RE: SUB19-002/SEP19-005 – 14-lot long subdivision proposed at 2825 W. Mercer Way
First Review & Request for Information
BlueLine Job No. 13-118

This letter is in response to your review of the 2825 West Mercer Way project. The plans have been revised per the comments in your letter dated August 2, 2019. Below is a list of each comment with our responses in bold.

3/1/19
 JOB NUMBER:
13-118
 SHEET NAME:
SP-01
 SHT **3** OF **9**

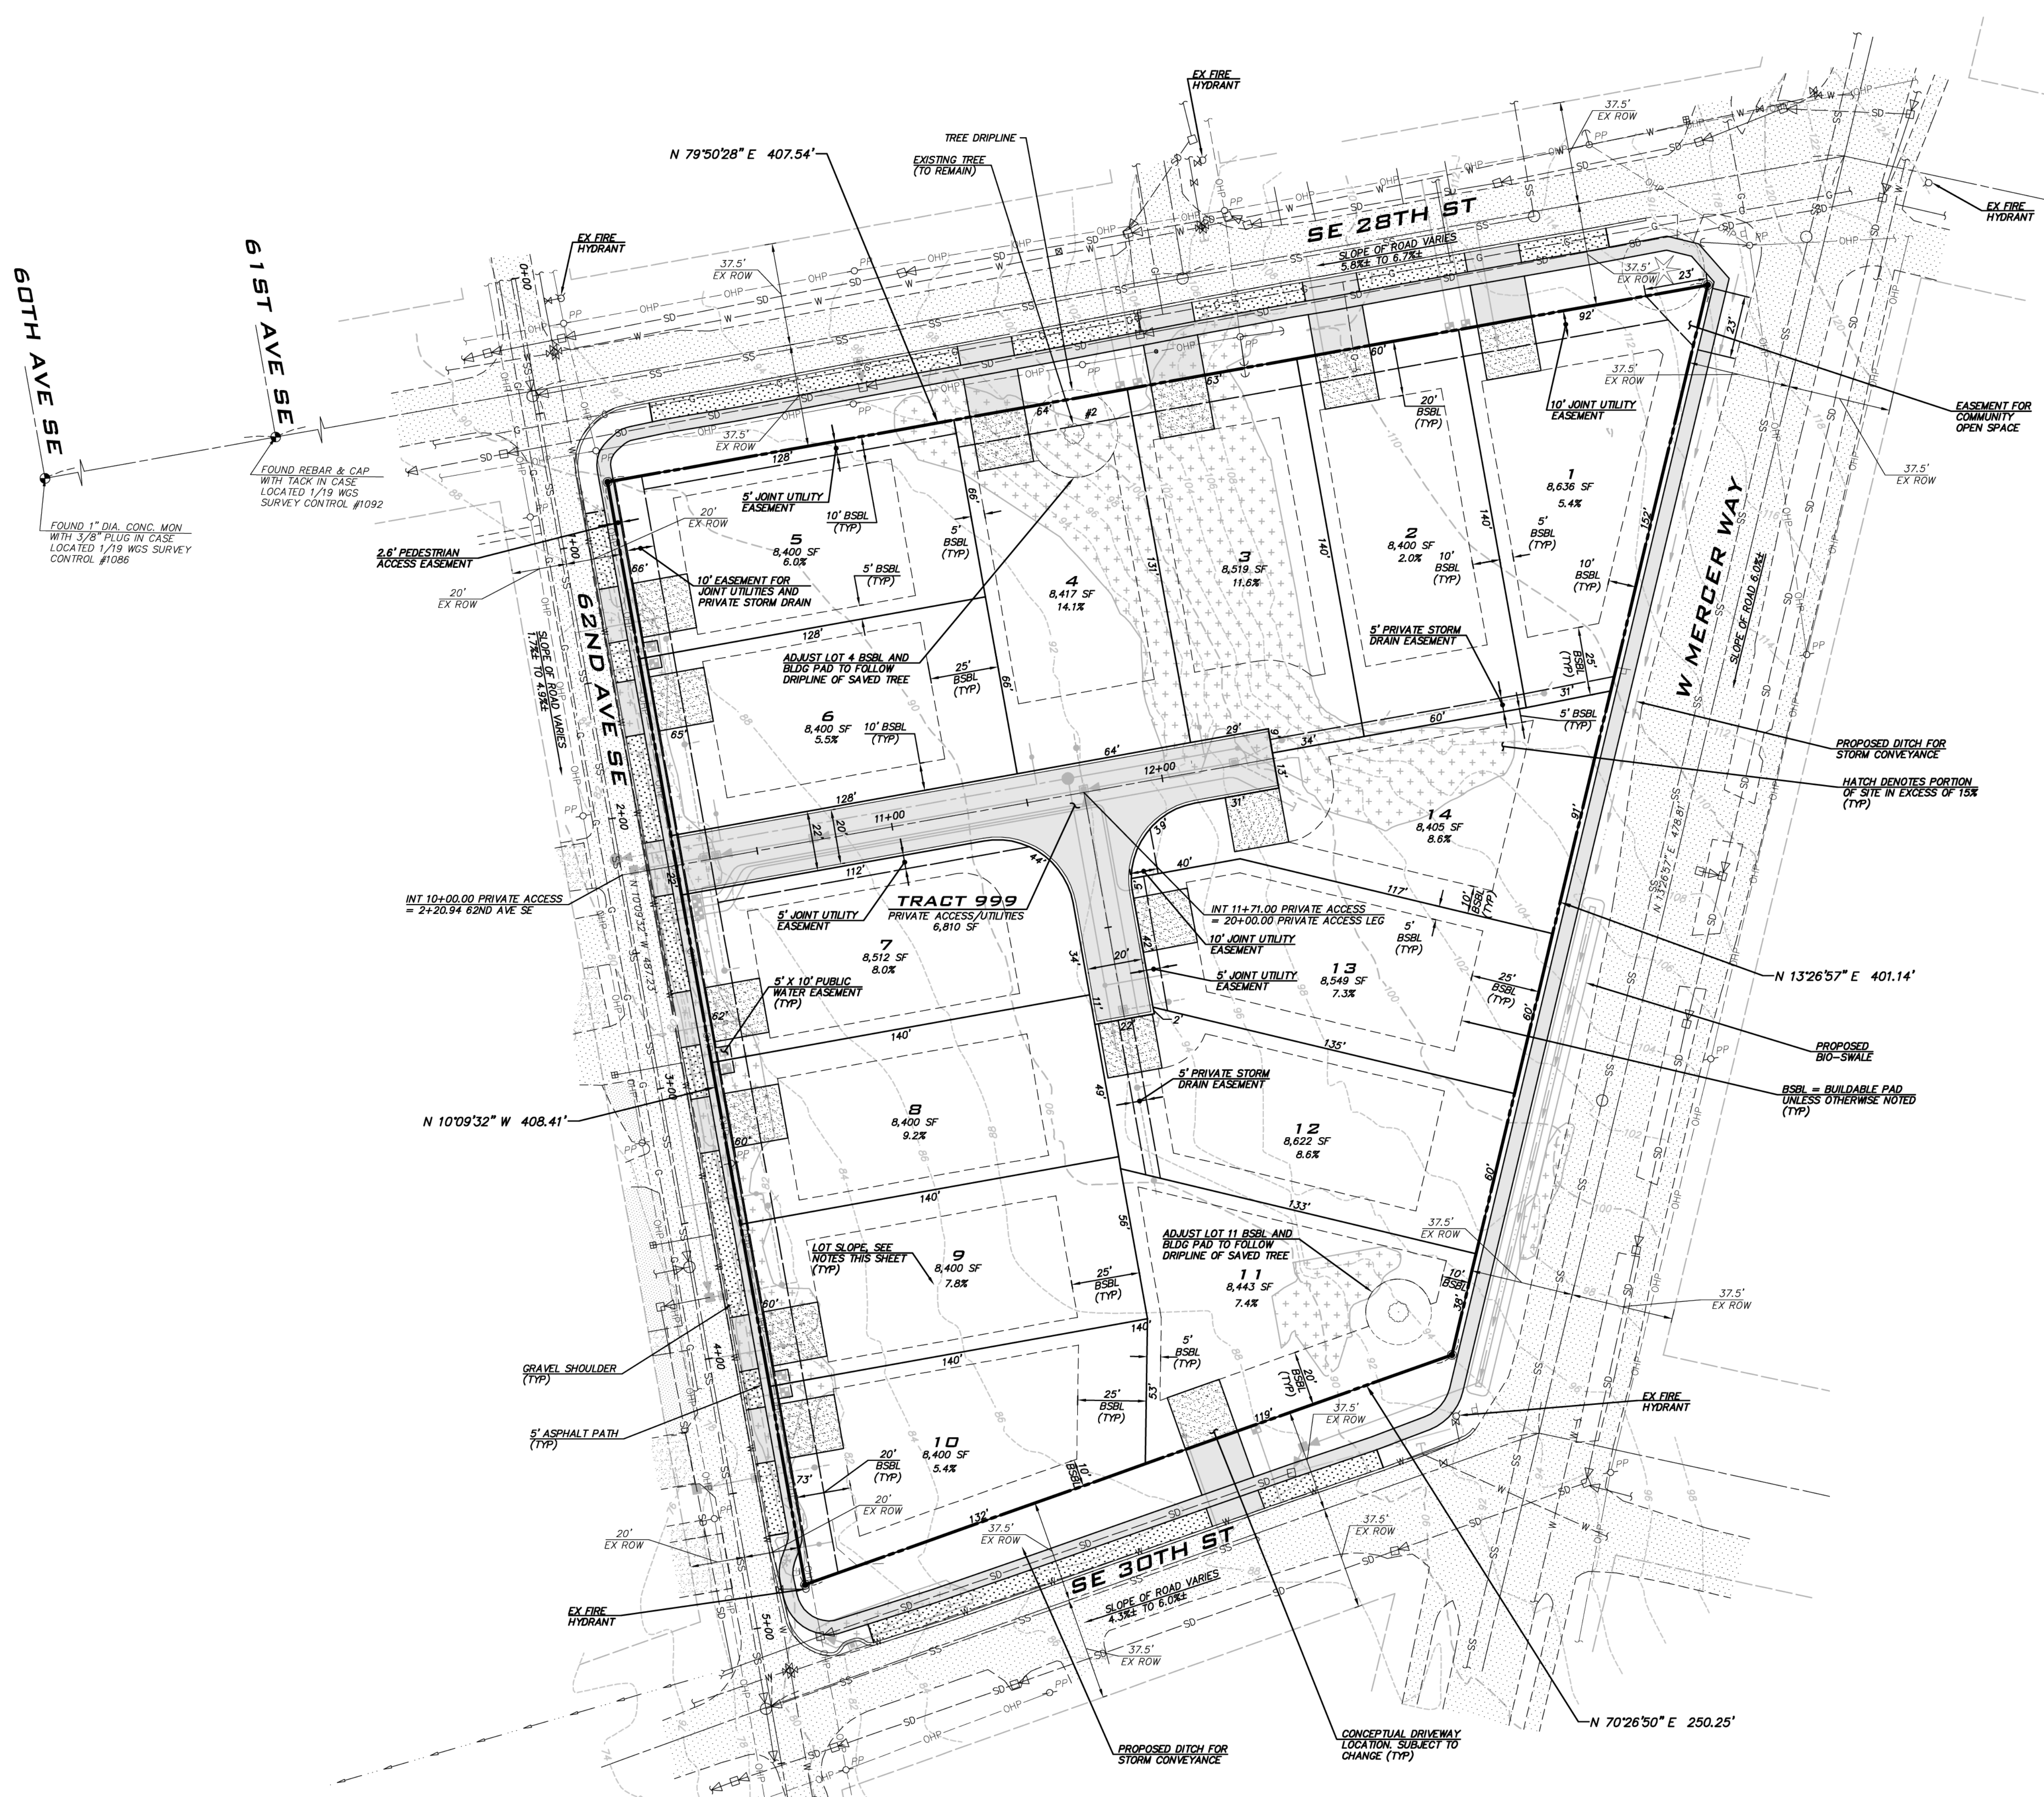
2. Sheet 3 - Demonstrate Tree #2 is sufficiently protected (will survive) with 16 feet of protection. Building pad, driveway, wall and associated grading will need to be shown outside this protection area. This means showing at least 5-ft of space between building pad and driveway in addition to the 16-ft protection area. Also, the building footprint should be revised to reflect a more accurate footprint, which may require a longer driveway and smaller house footprint.

The lot 4 driveway width has been reduced to accommodate a 2'-3' wall at the dripline as needed to avoid impacts to the limits of disturbance for the tree. Additionally, the wall between lots 4 and 5 and lot 4 grading have been adjusted to avoid impacts to the limits of disturbance for the tree.

TREE PROTECTION DETAIL
NOT TO SCALE

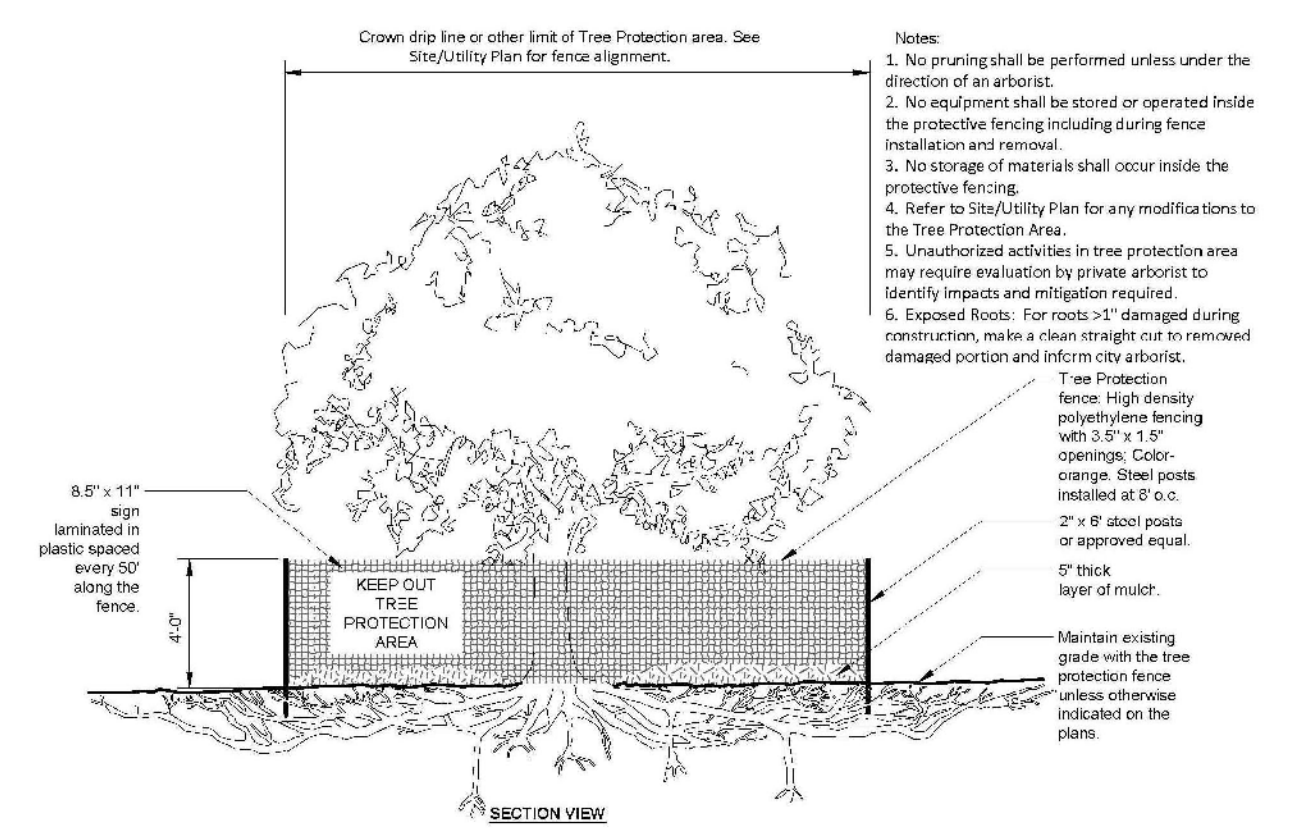
3. Chain link fence shall be used to protect all saved trees at their dripline. This will be required to be demonstrated on the site development plan. Please enlarge the notes on the detail provided on Sheet 8 provide a note on Sheet 8 to this effect.

The tree protection detail on Sheet 8 has been enlarged accordingly.

3/1/19
 JOB NUMBER:
13-118
 SHEET NAME:
UP-01
 SHT **5** OF **9**

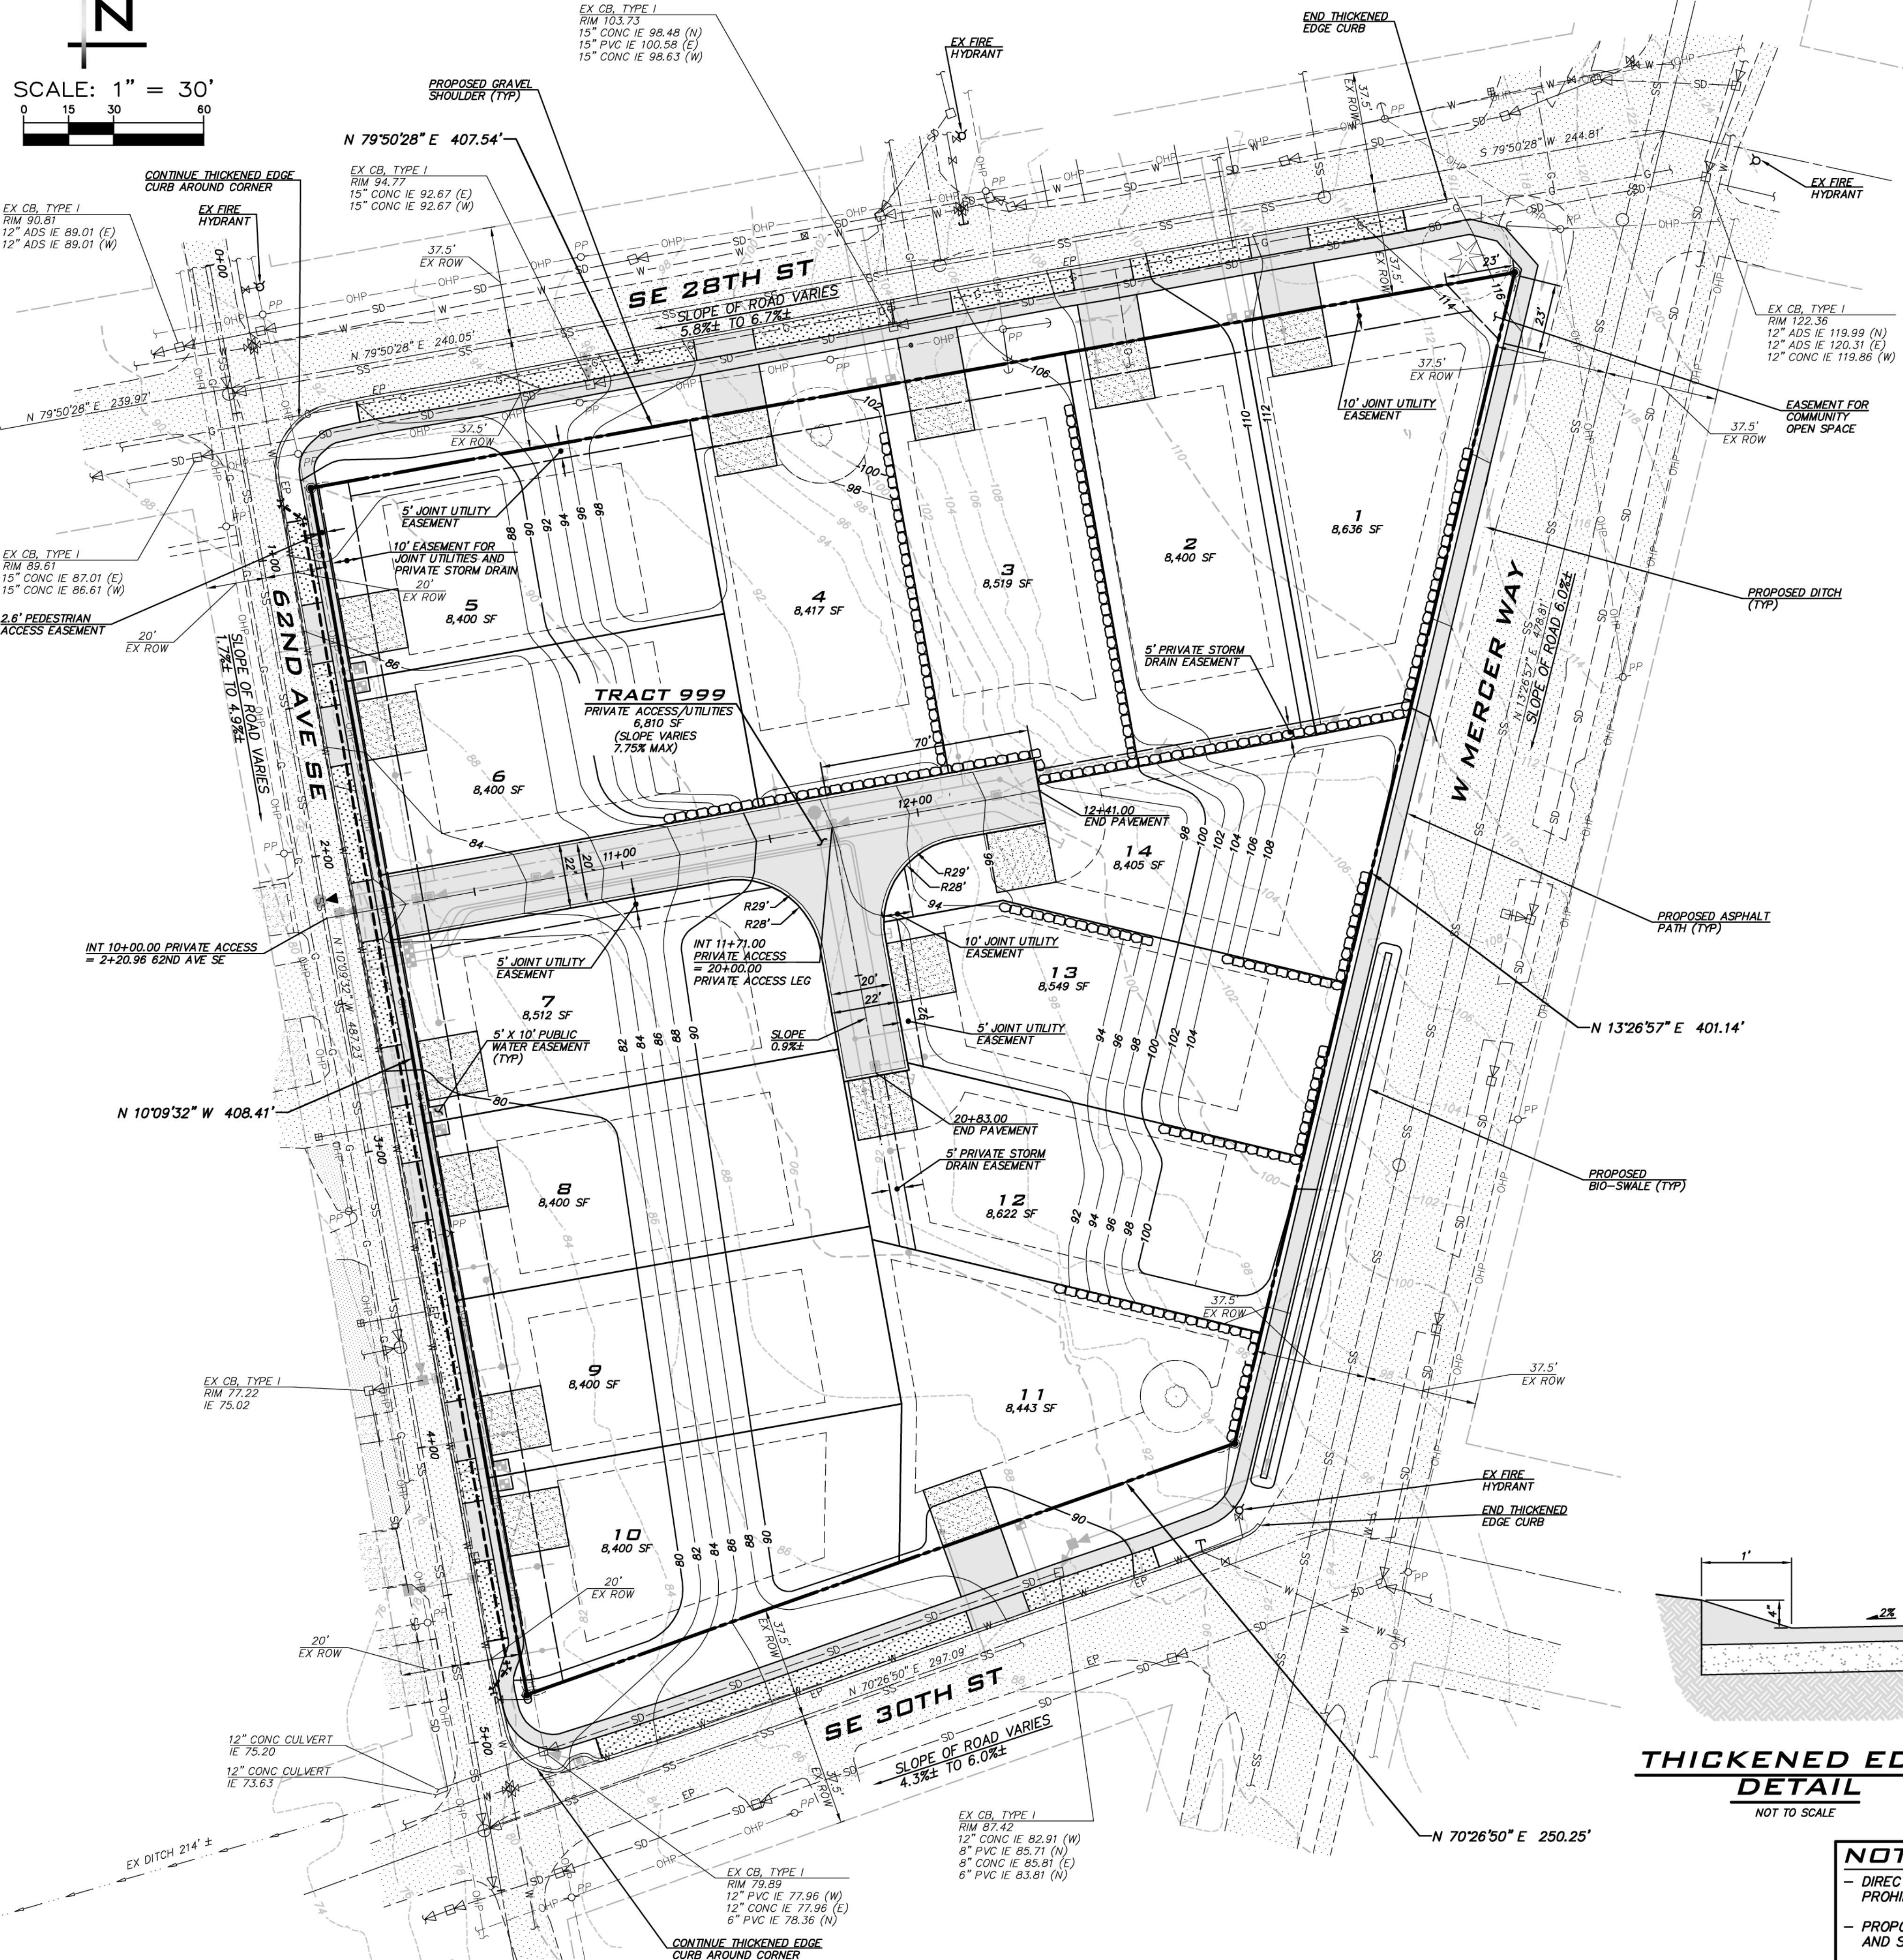
7. Please add the following note to the plan set: The utility design (water, sewer and storm) shown on the preliminary plans are conceptual only. They have not been reviewed for construction detail. The details, extents, alignments, locations, and all design-related features are not approved and will be further reviewed with the Site Development Permit.

This note has been added to the preliminary utility plan sheet (UP-01).
